From: Martyn White <Martyn.White@arun.gov.uk>
Sent: 14 June 2022 16:57
To: Planning.Responses <Planning.Responses@arun.gov.uk>
Cc: Simon Davis <Simon.Davis@arun.gov.uk>
Subject: BR/93/22/DOC

BR/93/22/DOC

65-71 Upper Bognor Road Bognor Regis PO21 1HR

Approval of details reserved by condition imposed under BR/252/21/PL relating to conditions 8-details of eaves, guttering, materials, window, doors and other external finishes, 10-landscape scheme, 11-boundary treatments, 14-bat and hedgehog nesting facilities and 17-charging of electric vehicles.

DWG NO	REV.
1127/P/201	A

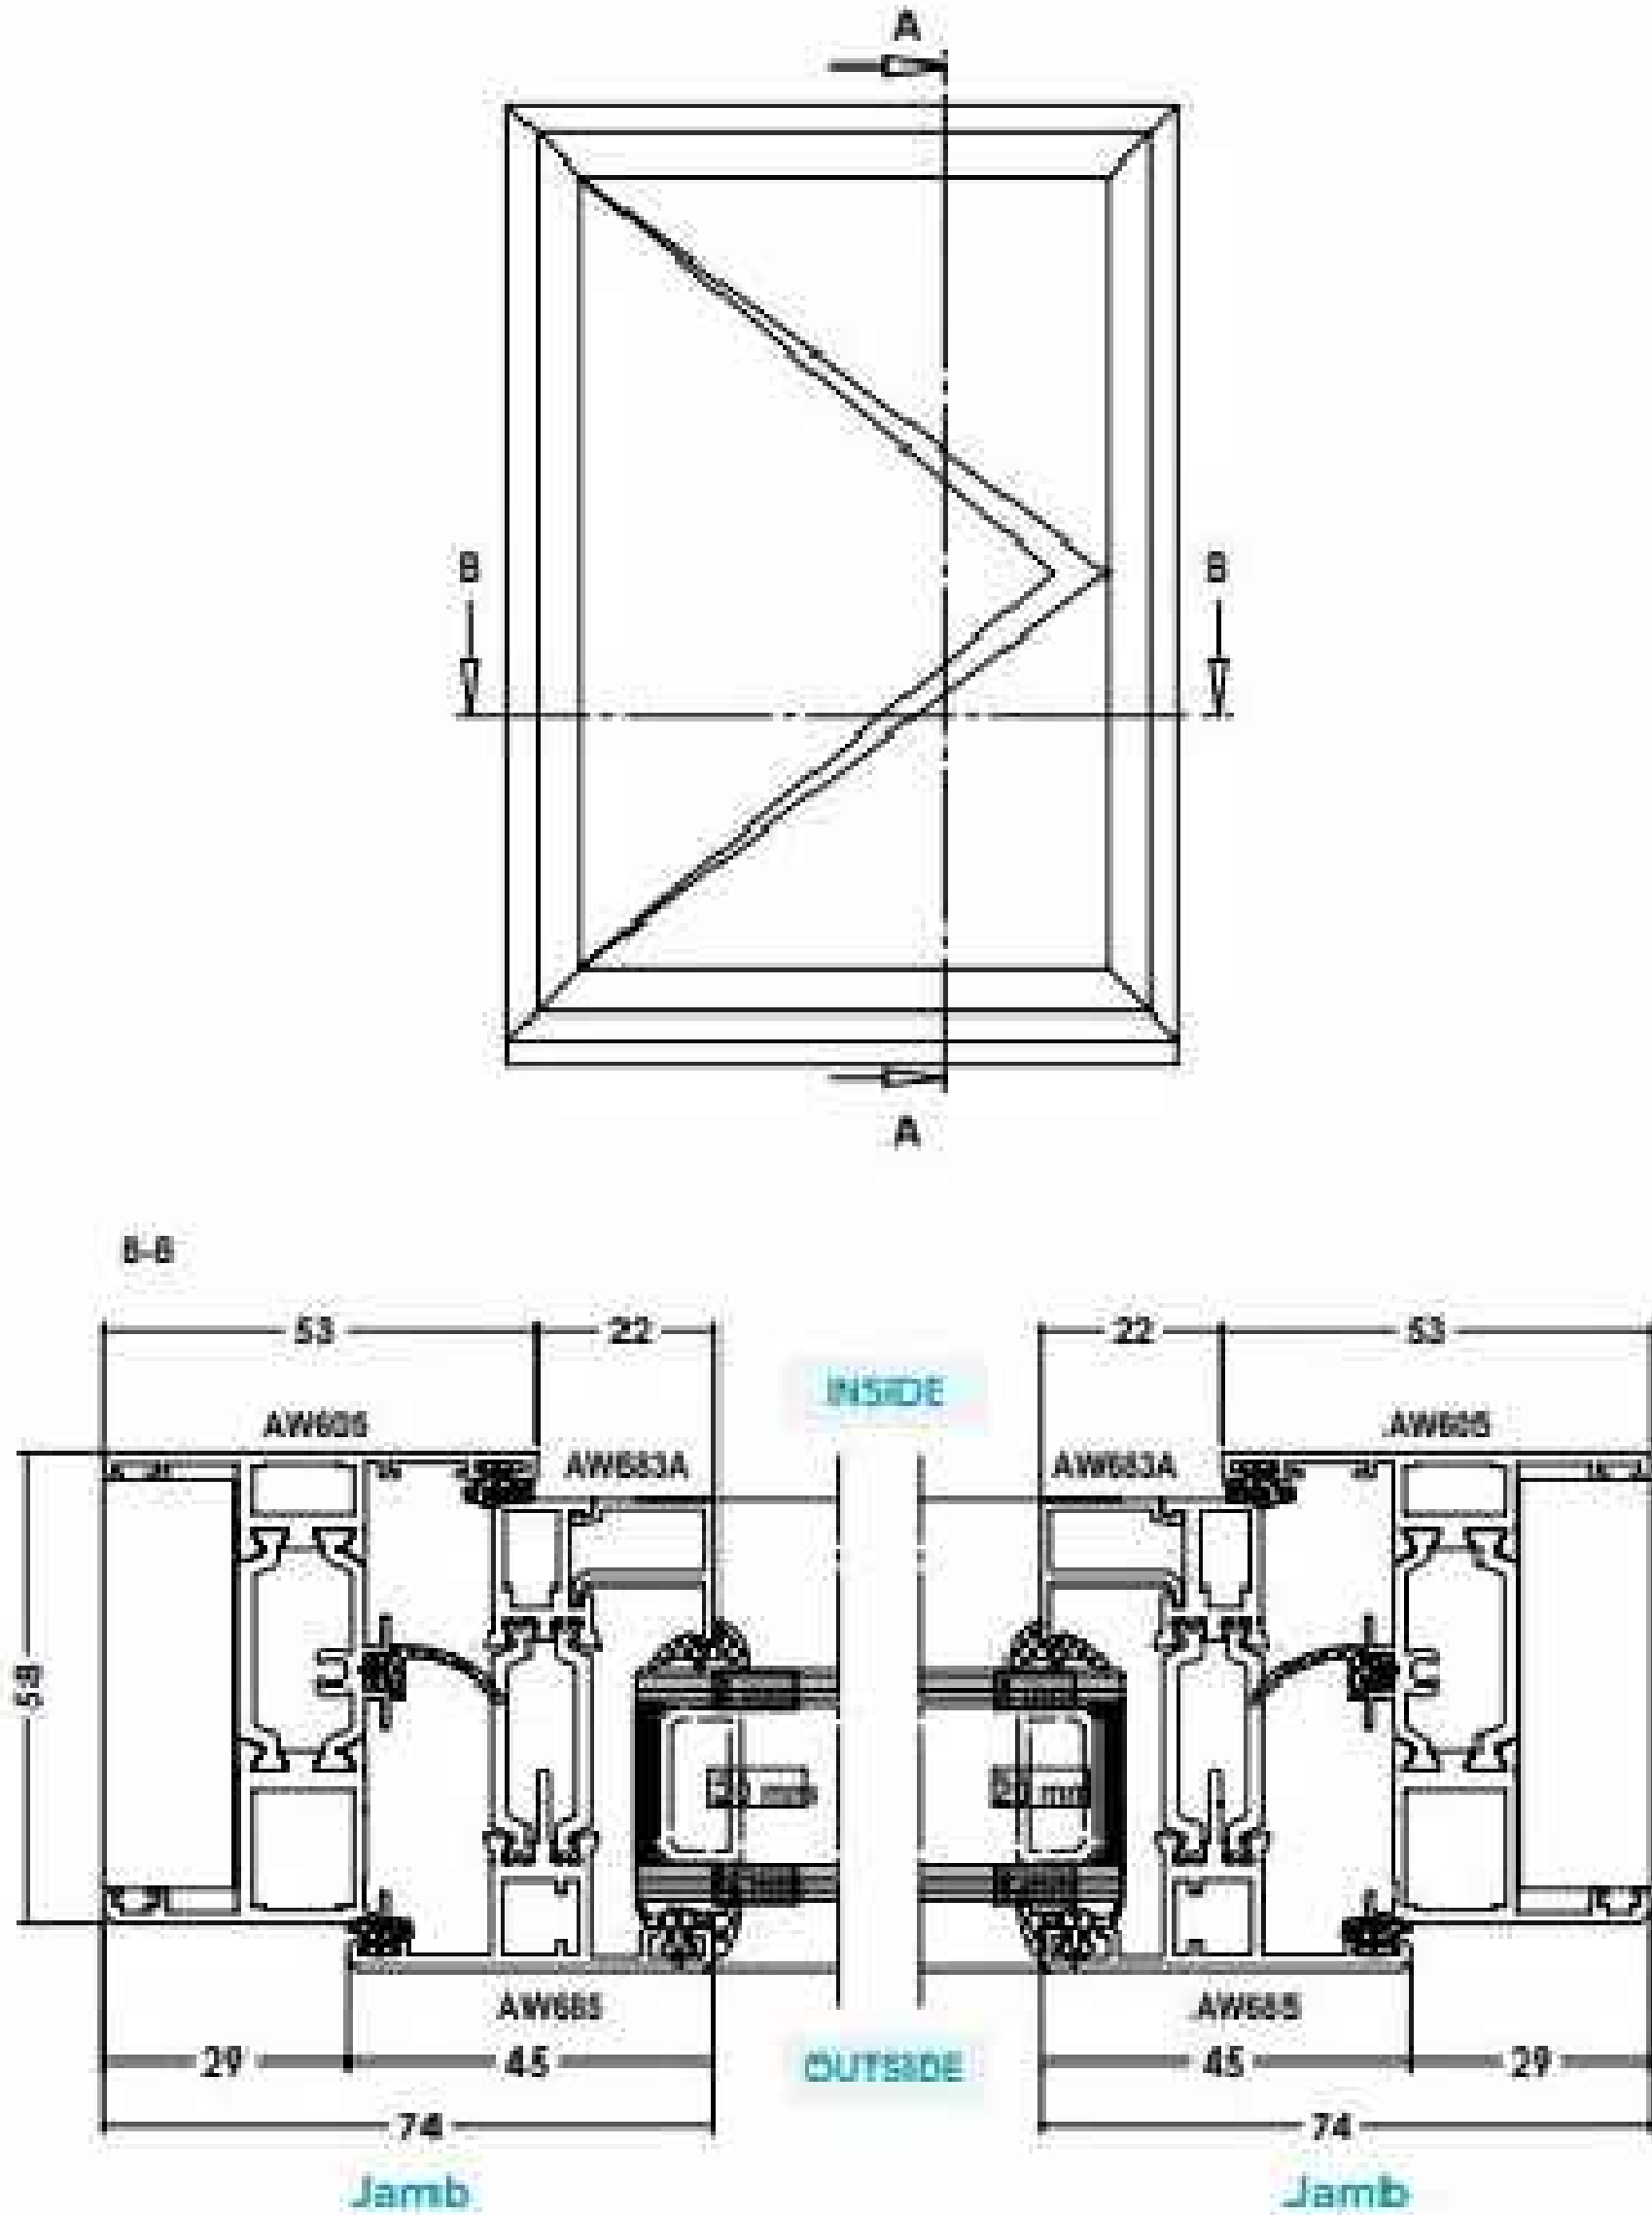
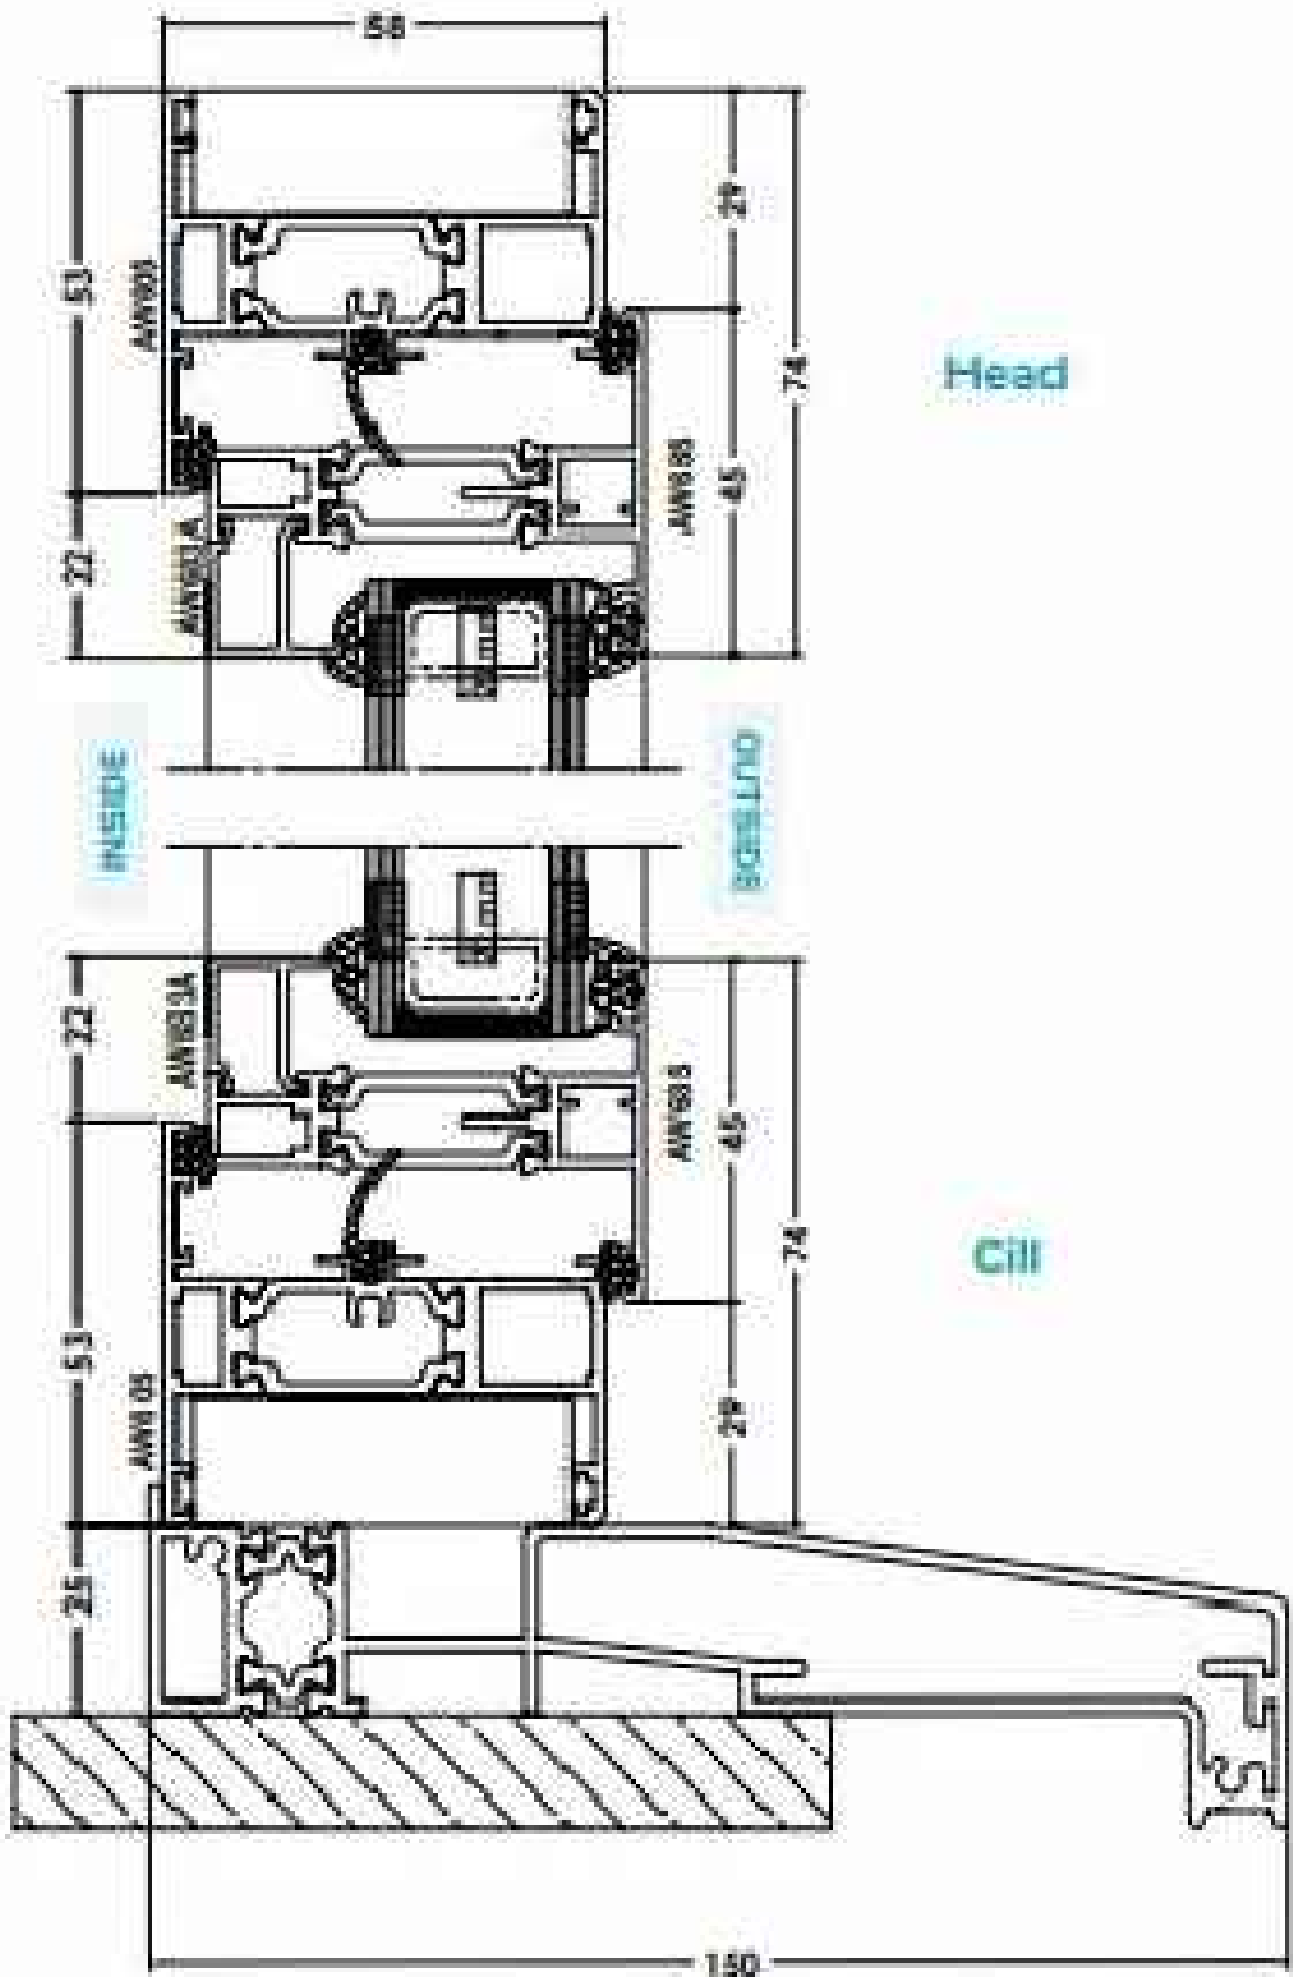
The details of the windows for the new building as proposed to be aluminium, which is an acceptable material (for just the new build). The details of the frames are generally acceptable, but do not show how the glazing bars will function i.e. integral to the frame or applied. Glazing bars were provided on the proposed elevations and formed part of the reason for the development being considered acceptable from a heritage perspective – the application noted that they were to match the windows of no. 67 & 69. I am also unable to see details of the colour. Therefore, further information is required.
